File No: NTH07/01158/16

Your Ref: SSD-10398

RE: Major Projects – EIS - Hanson Tweed Sand Plant Expansion (SSD-10398)

Attachment A - Technical Comments

FIGURE 19: EXTRACTION PHASES

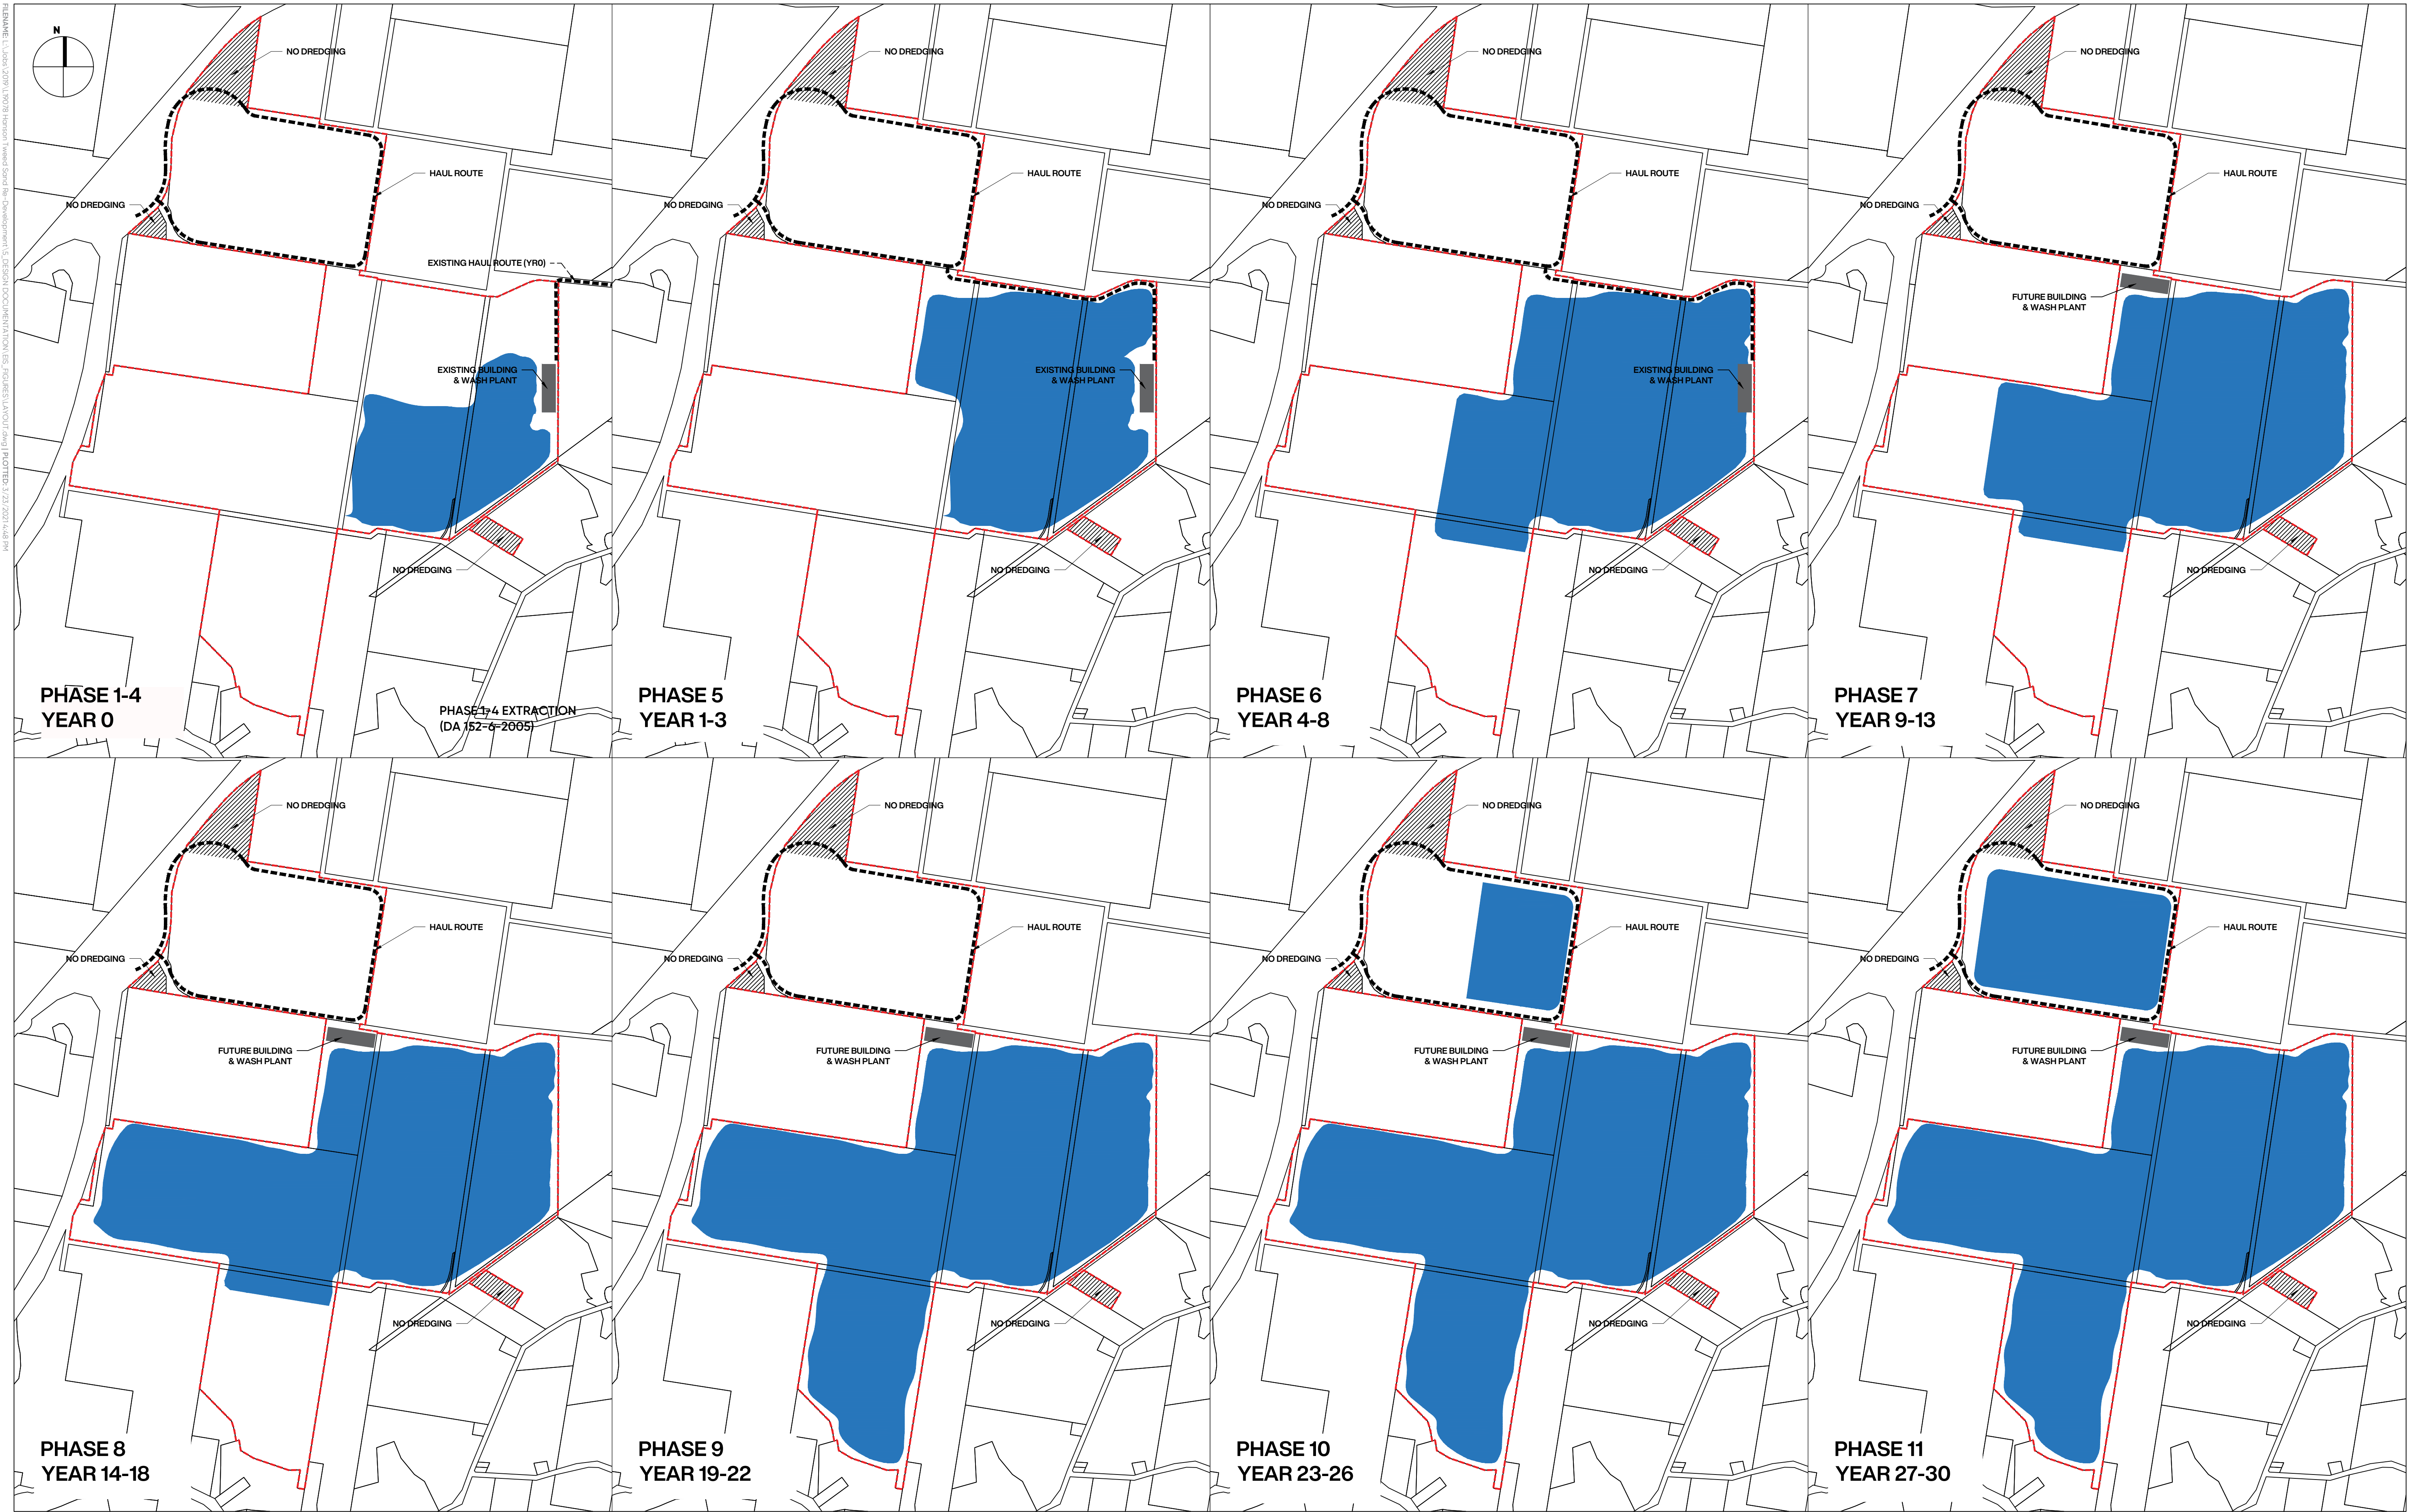
6. The EIS proposes the extraction of material to a depth of 20m below ground level and within 10m of the project site boundaries. Appendix A13 identifies that the phases 8 and 13 of extraction will be in the vicinity of the Pacific Motorway interchange. TfNSW has concerns regarding the proposed depth and proximity of extraction to the Motorway and the resulting implications for future planning and State infrastructure.

TfNSW is seeking internal geotechnical advice and will further advise the Consent Authority of an appropriate setback from the Freeway corridor to ensure the final arrangement is safe, secure and stable. Our interim request is that the Consent Authority impose a hard setback of 40m from the Freeway corridor boundary.
